21 January 2021

Subject: Geotechnical Engineering Review of Gilman Street Temporary Support of  
Excavation Design  
Maine Medical Center Hospital Expansion  
Portland, Maine  
RWG&A Project No. 0557-031

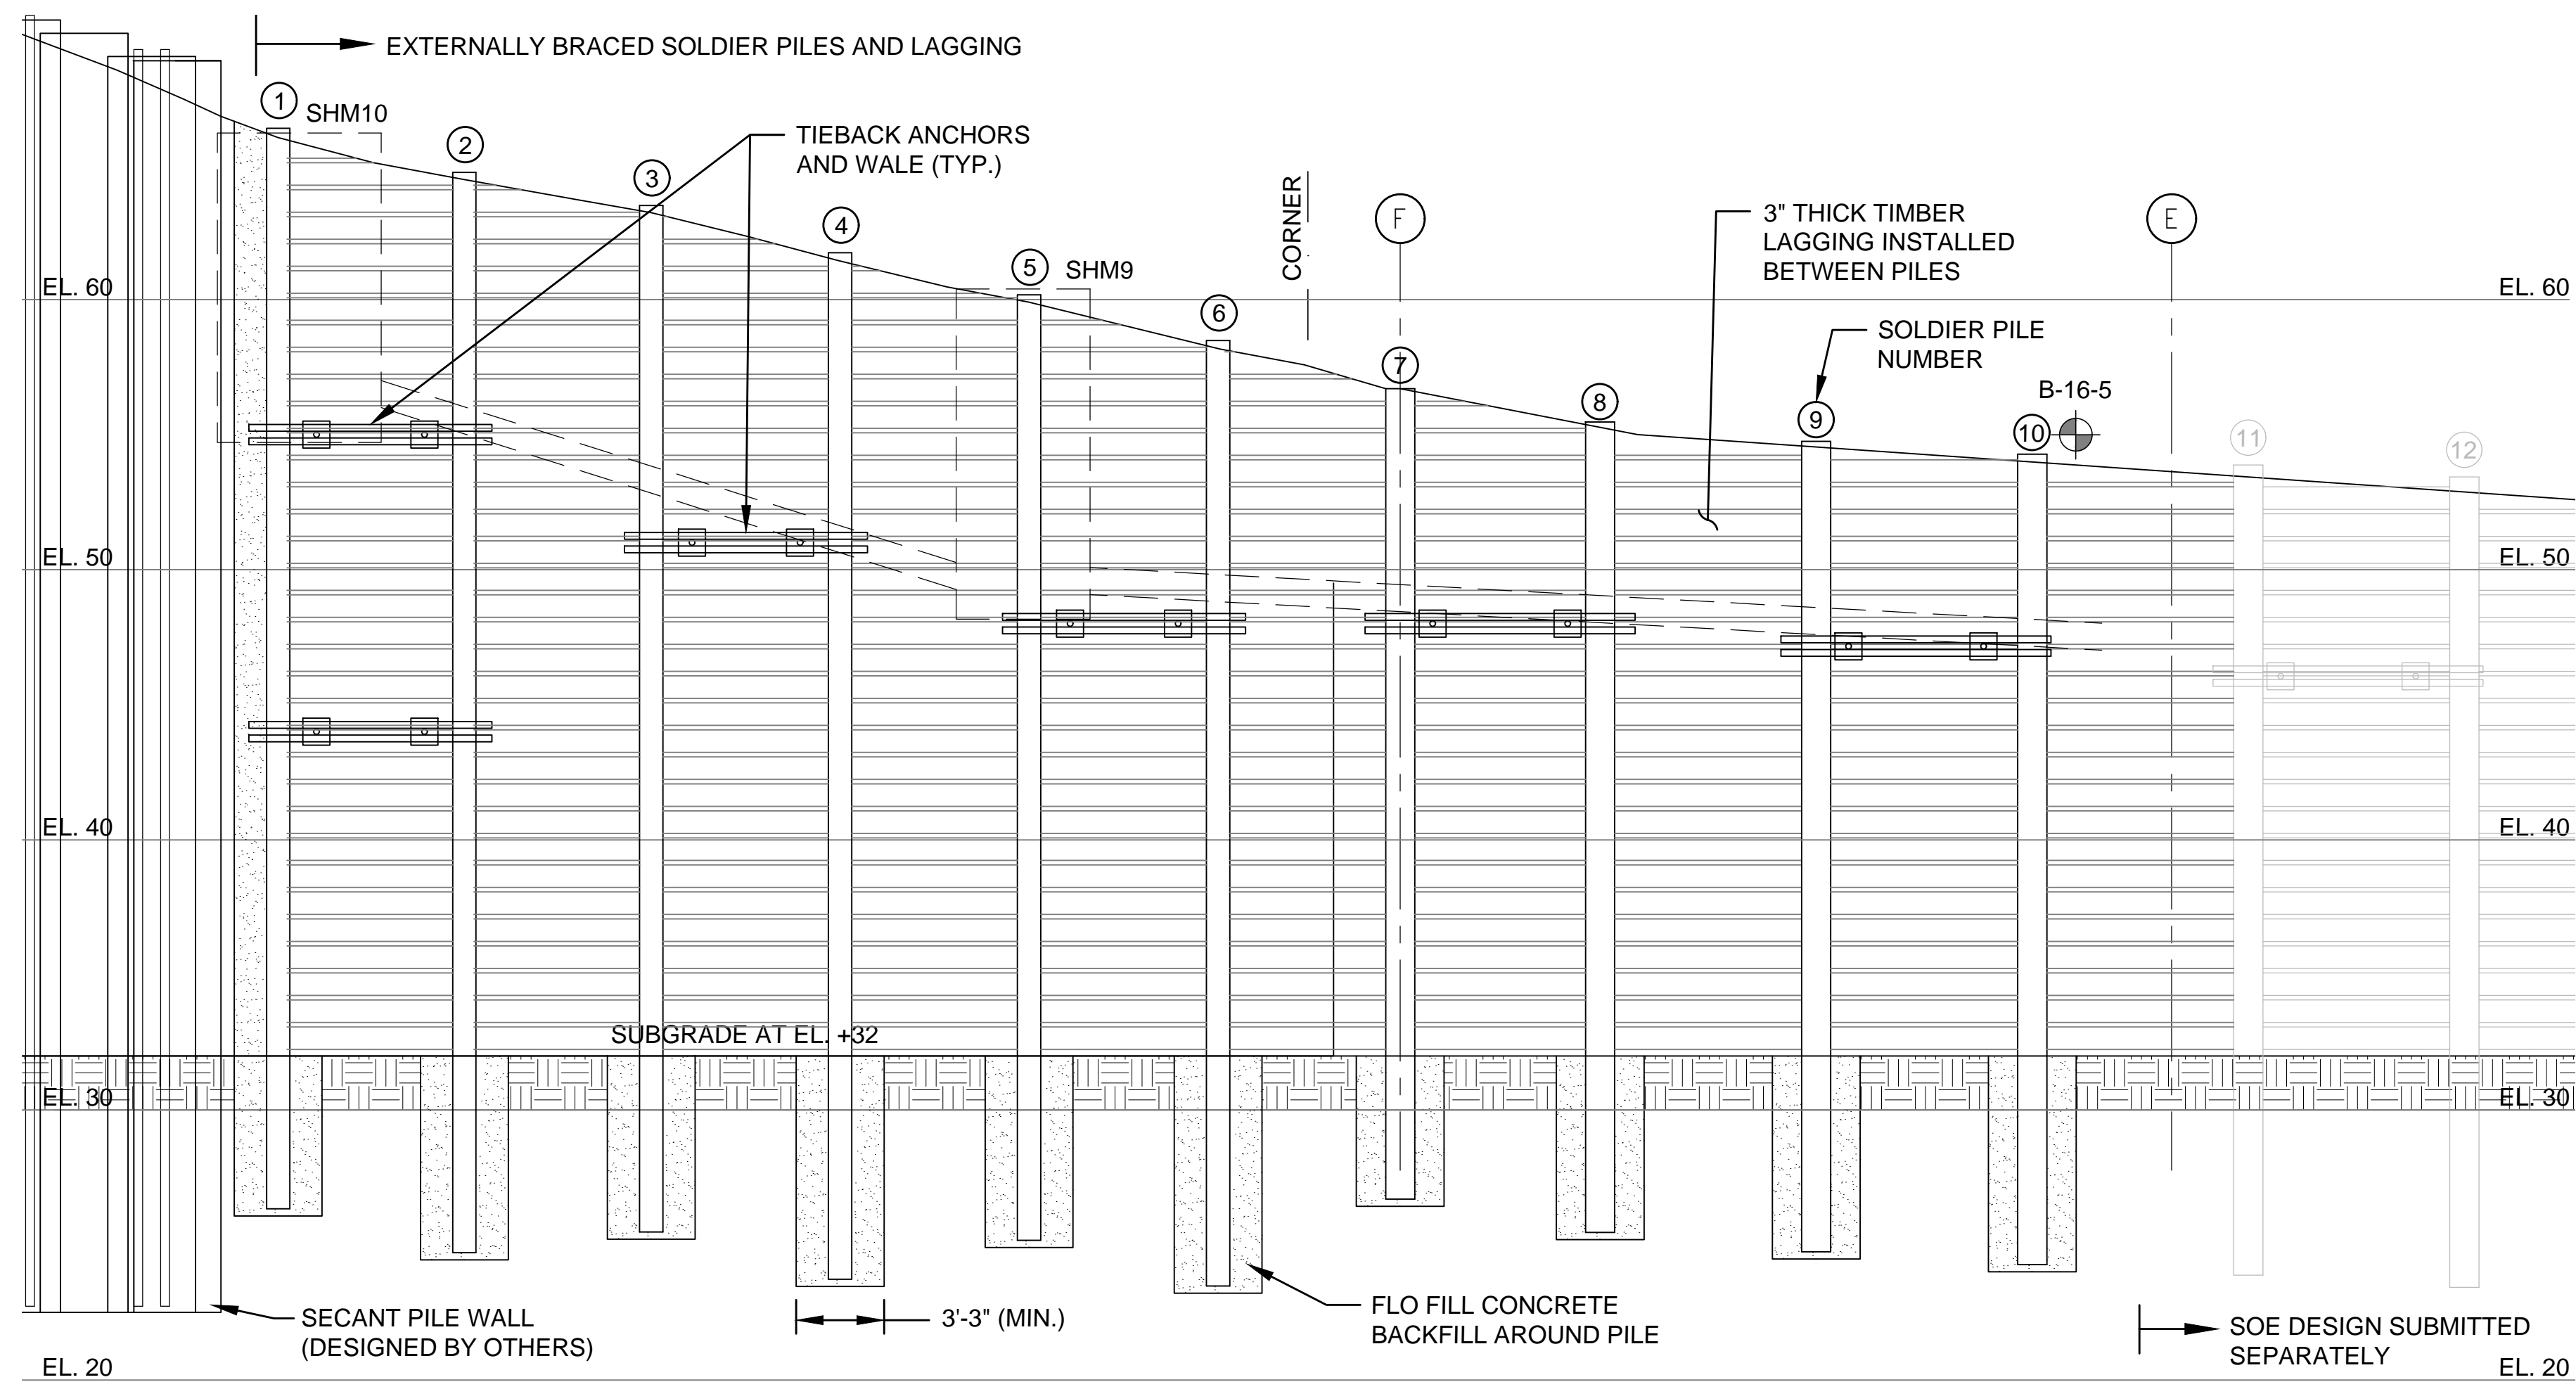
Based on the enclosed sketch titled *Section at Gilman St. Looking South Look South, Tieback 9 & 10*, the tiebacks would pass about 5 feet below an electrical duct bank, about 9 feet below a 6-inch waterline, about 5 to 7 feet below the bottom of SMH-8 and SMH-13533, and about 16 feet below a 4-inch natural gas pipeline at the west side of Gilman Street. The Contractor proposes to abandon four grouted soil tiebacks and four steel, H-shaped soldier piles in-place after the excavation between the SOE system and building foundation walls is backfilled. The H-piles are about 24 inches square in plan dimensions and would be surrounded by "flo fill" which we understand is a low-strength concrete. The sketch indicates that the "flo fill" and soldier piles would be removed to a depth 6 feet below the final grade after completion of foundation work.

Anchor Tieback Limits: The sketch prepared by Turner indicates that the Gilman Street right-of-way is 60 feet wide. The design calls tieback 65 feet long installed at a 20-degree downward angle. Based on the length and angle, the tiebacks would extend a horizontal distance of about 61 feet. It appears from the wale-to-pile connection detail that about 1 foot of the tieback would be located on the project side of the boundary, which would locate the end of the tieback very close to the Gilman Street westerly right-of-way boundary. If there are deviations from the design tieback lengths and inclinations, or in soldier pile positions, it is conceivable that the tieback might extend outside of the right-of-way and into the abutter's property.

*MMC should affirm that survey, construction, and design modifications are in place to assure that the tieback system will not extend beyond the westerly right-of-way boundary. The contractor should indicate how location, length, and angle control will be maintained and verified during installation.*
